DMJM/Adam, Hamlyn, Anderson

April 5, 1984
Mr. Billy Goolsby
City of Albuquerque, Hydrology
PO Box 1293
Albuquerque, NM 87103

Re: Grading & Drainage Plan for Parking Lot For NAPA
Albuquerque Facility (J14-D40)

GRADING & DRAINAGE PLAN

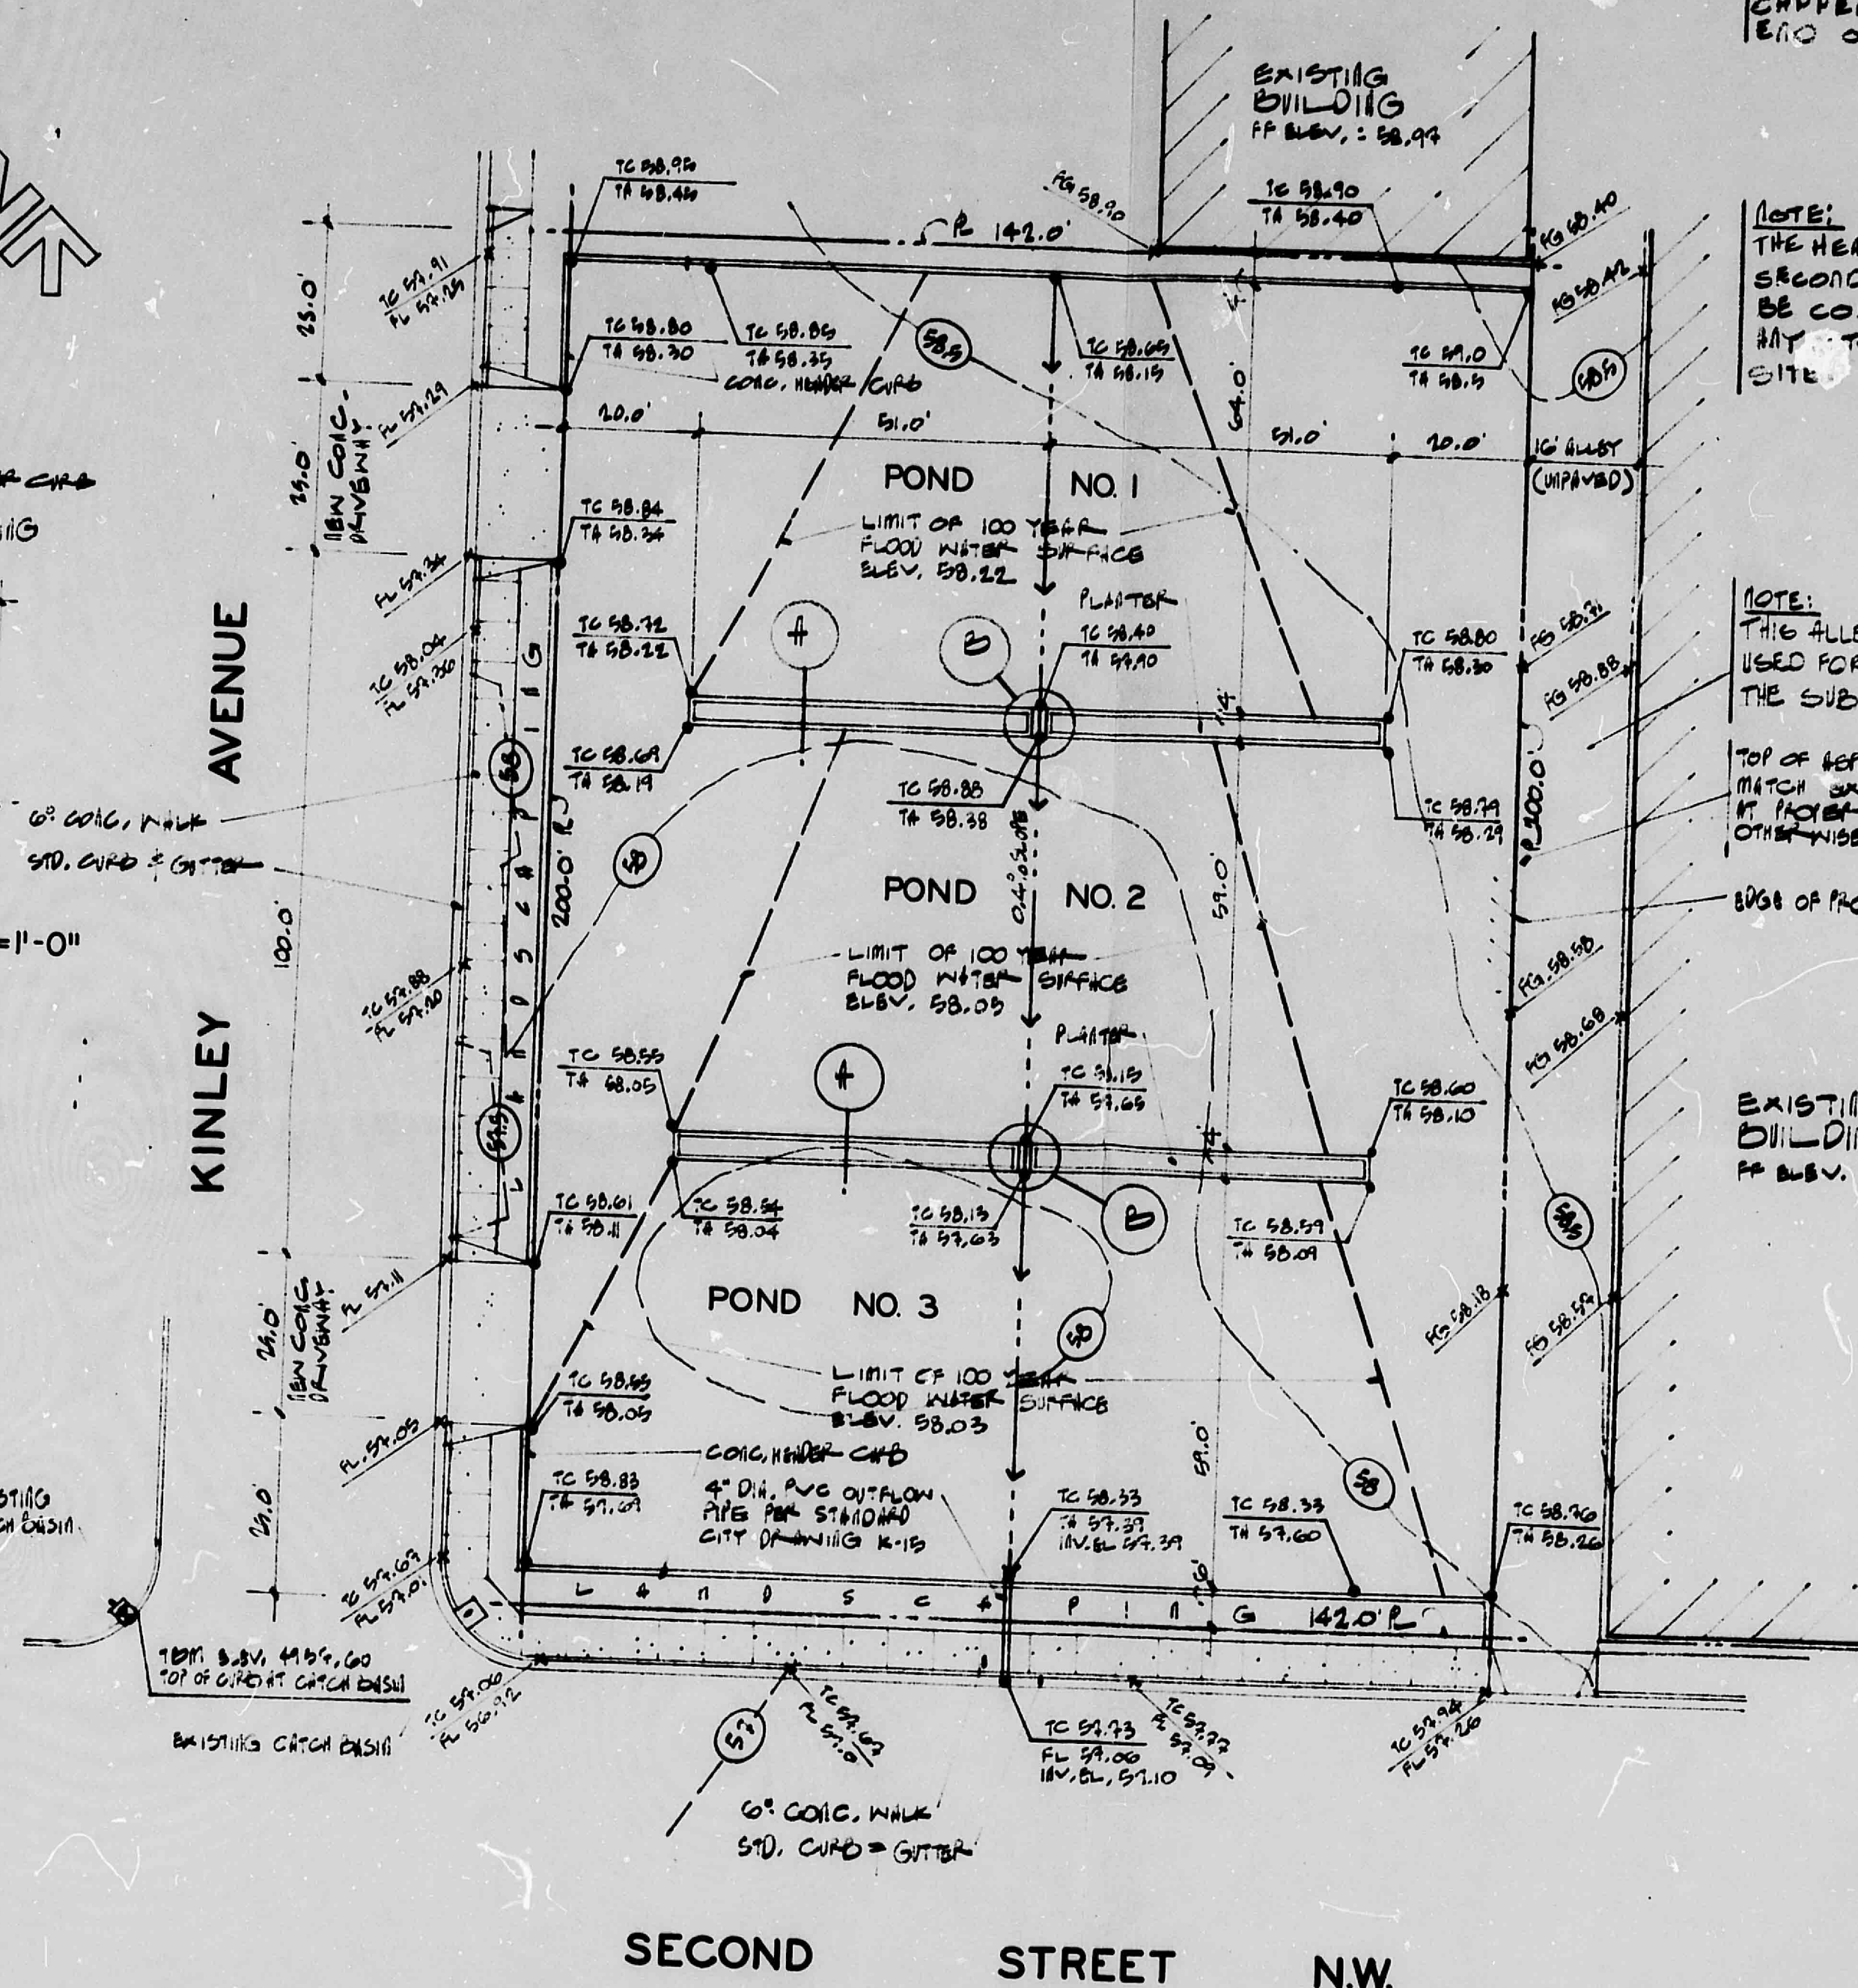
1. There is no offsite flow entering this site.
2. Peak discharge rate from the site is 0.289 cfs with a maximum head of 0.48 feet and emergency spillways is the Drivepad located at the NW corner of the site.
3. A note has been added to the plans and the site shall not be accessible from the adjacent alley. The existing alley is approximately 1/2 foot above the finish floor of the adjacent building and I would rather not be responsible for setting grades and subjecting myself to the potential liability that could be incurred.
4. Legal description has been added to the plans.
5. A note regarding sequence of construction has been added to the plan, which will affect Erosion Control.
